Subject: RE: Attached letter from Kirklees Council regarding application number 2024/91971 at location Land at, Green Acres Close, Emley, Huddersfield, HD8 9RA

I would like to advise that condition 11 (drainage) cannot be discharged pending the necessary rectification of the notes in the submitted drawings, as advised, together with the submission of a satisfactory "Design & Check Certificate" for oversize manholes.

Drawing No: AMA/23336/D/500 Rev: P10

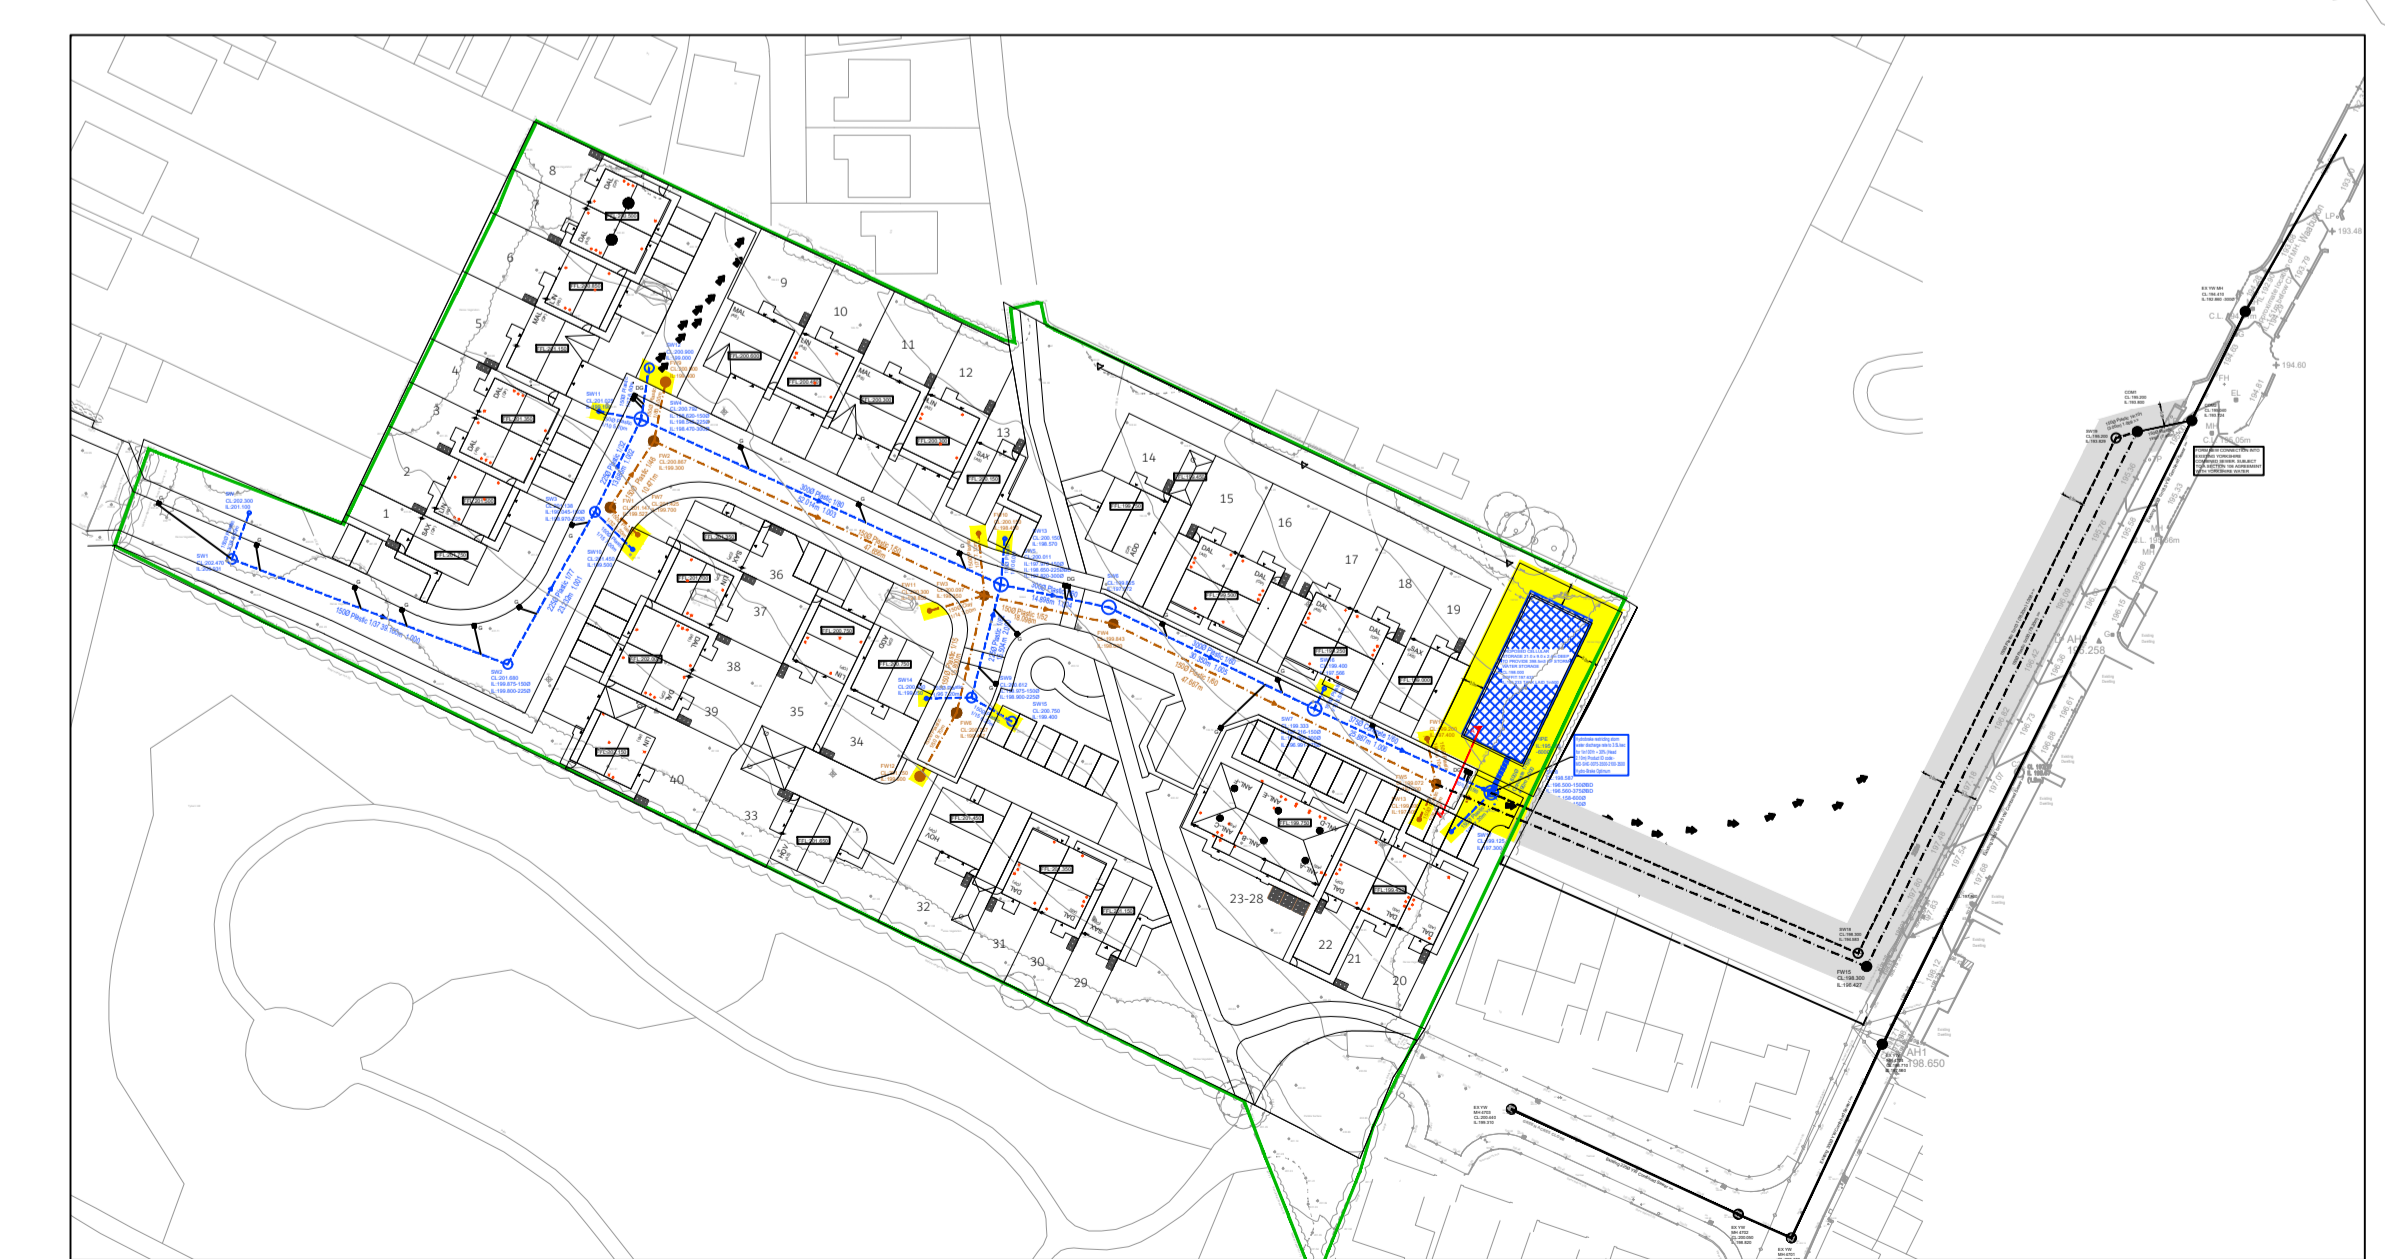
I understand that the drainage works may have been completed in advance of acquiring a technical approval for these structures.
